Discharge of condition 20 - location & installation of fire hydrants.

Application No: Y/77/21/DOC
Registered: 1st June 2021
Site Address: Street Buildings North End Road Yapton BN18 0DT
Description of Works: Approval of details reserved by condition imposed under ref Y/13/18/PL relating to Condition Nos 8 - design & construction drawings for the means of access/egress onto North End Road and 20 - location & installation of fire hydrants.

NORTH END ROAD, YAPTON
MAINS DESIGN

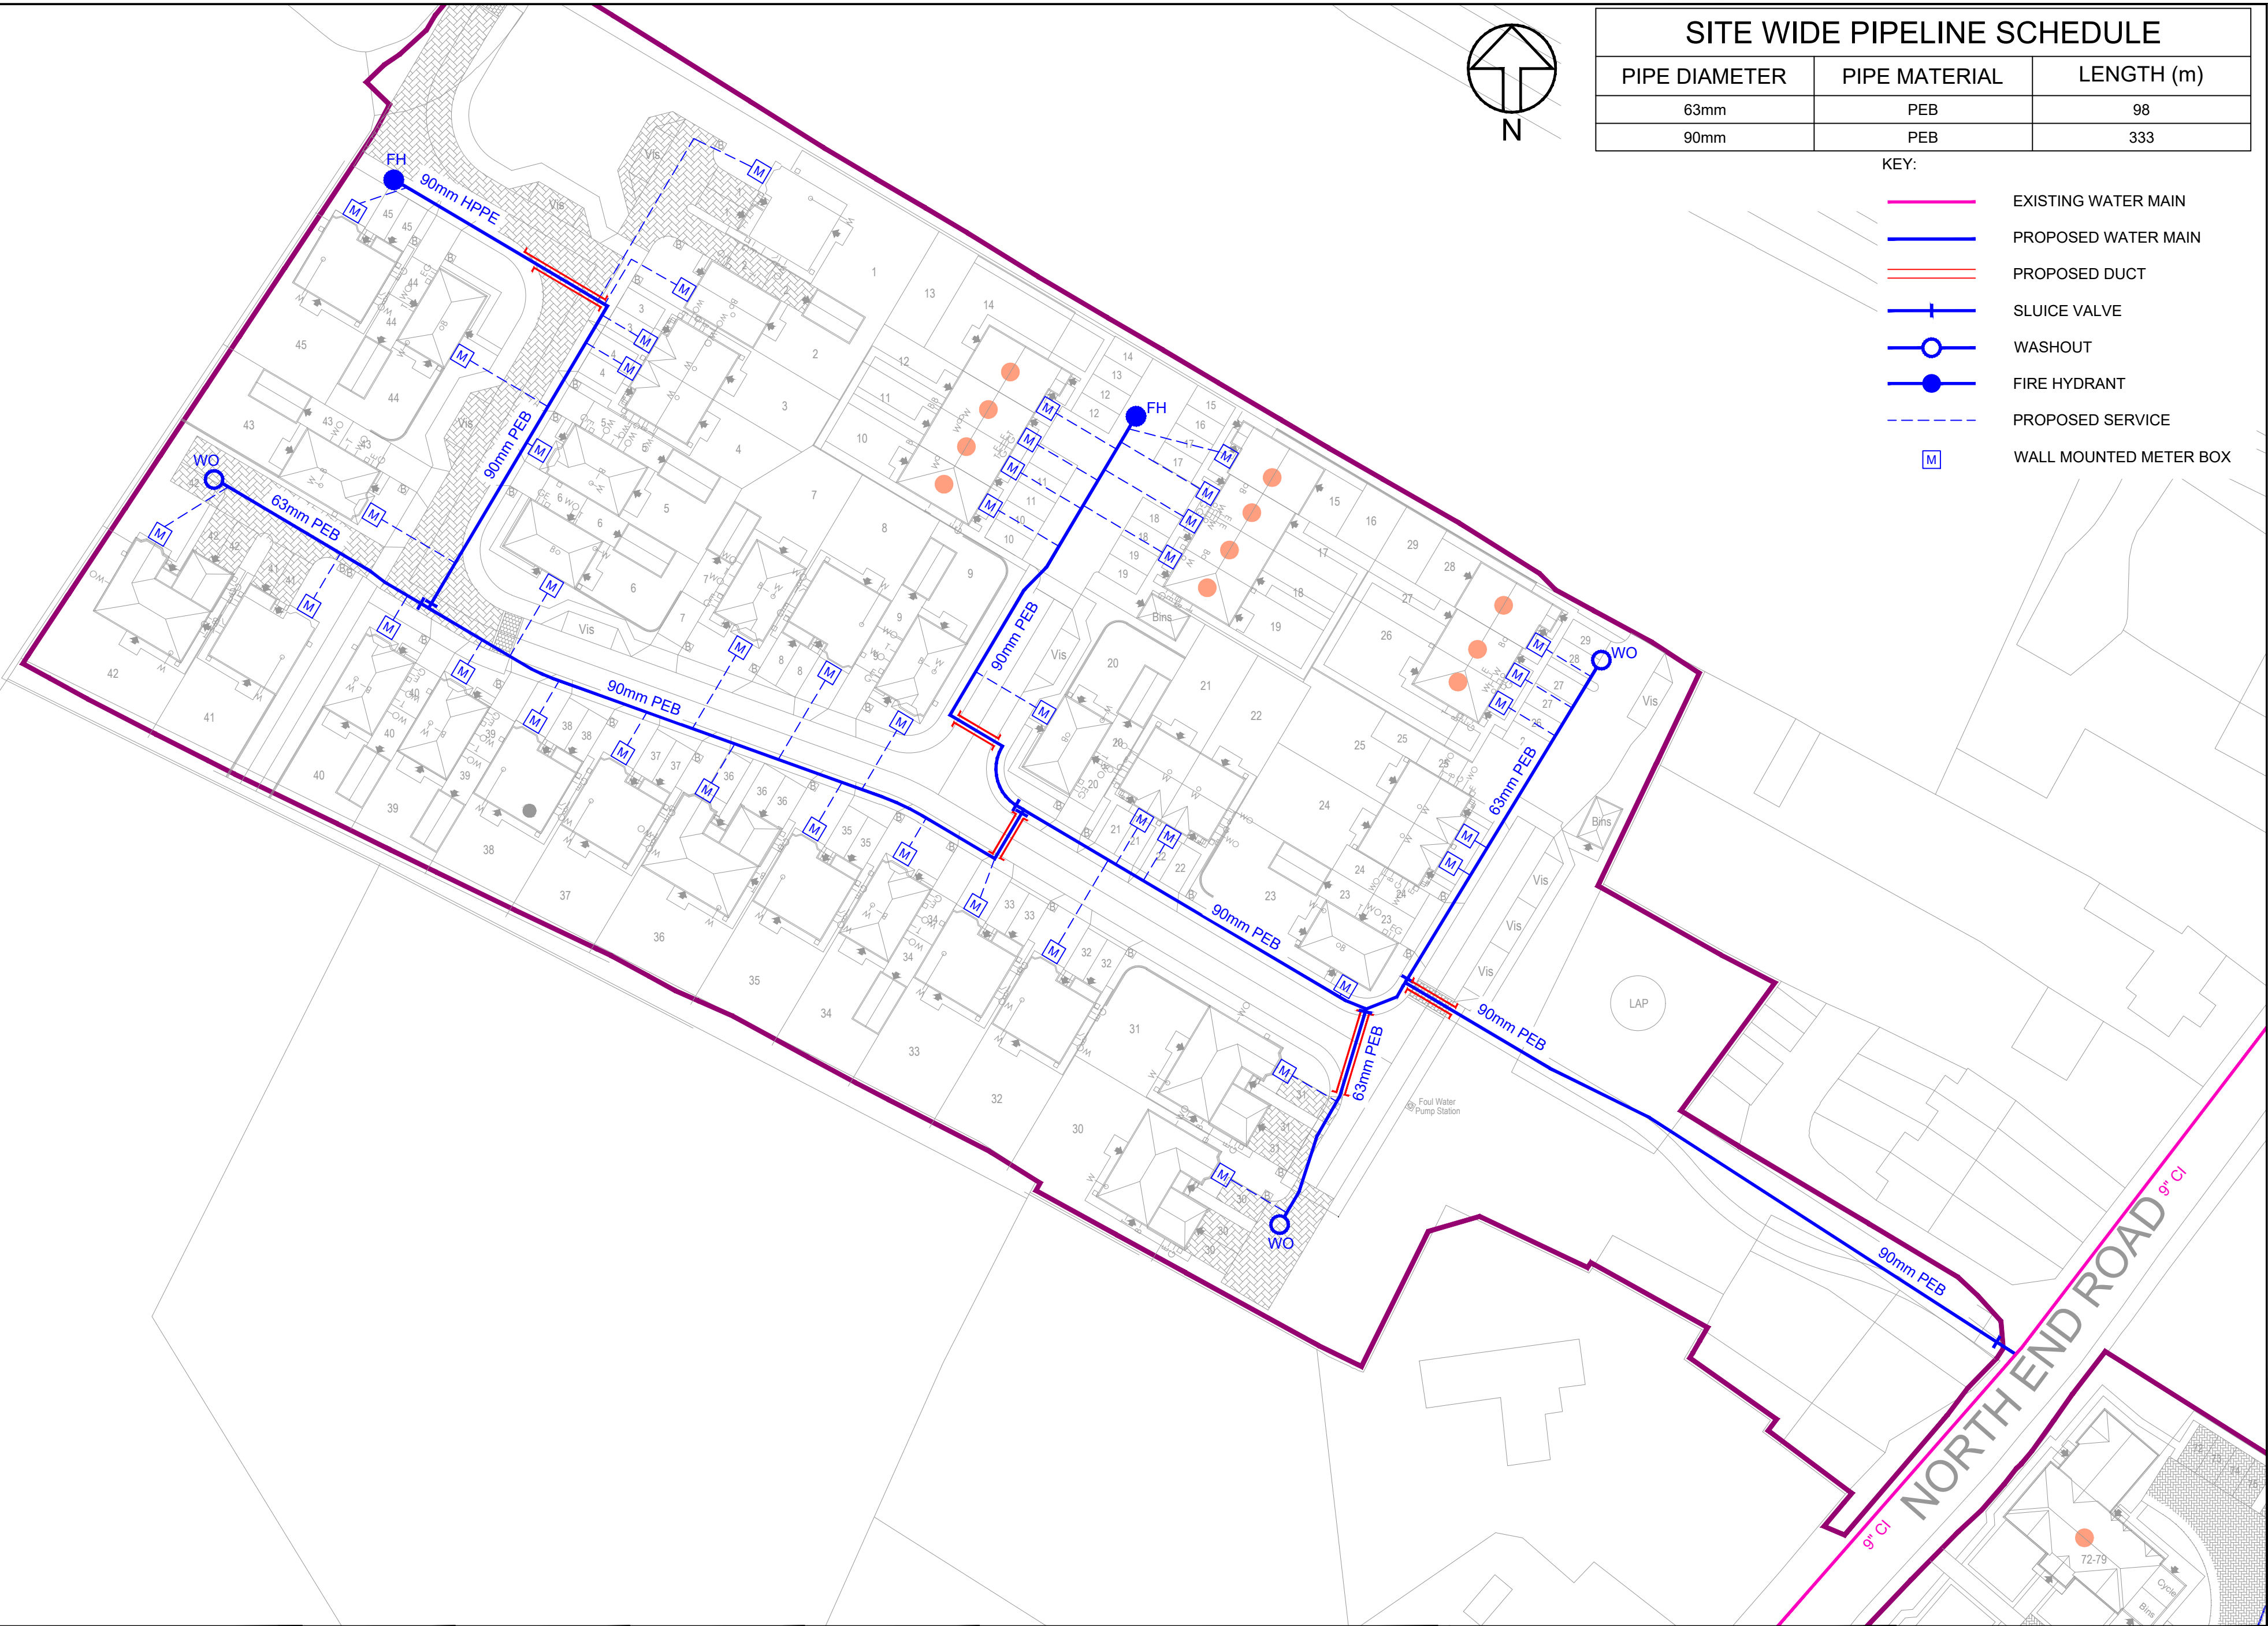
Providing the hydrants indicated on the mains water plan are installed the provision of fire hydrants for this planning application would be considered met and the condition can be discharged.
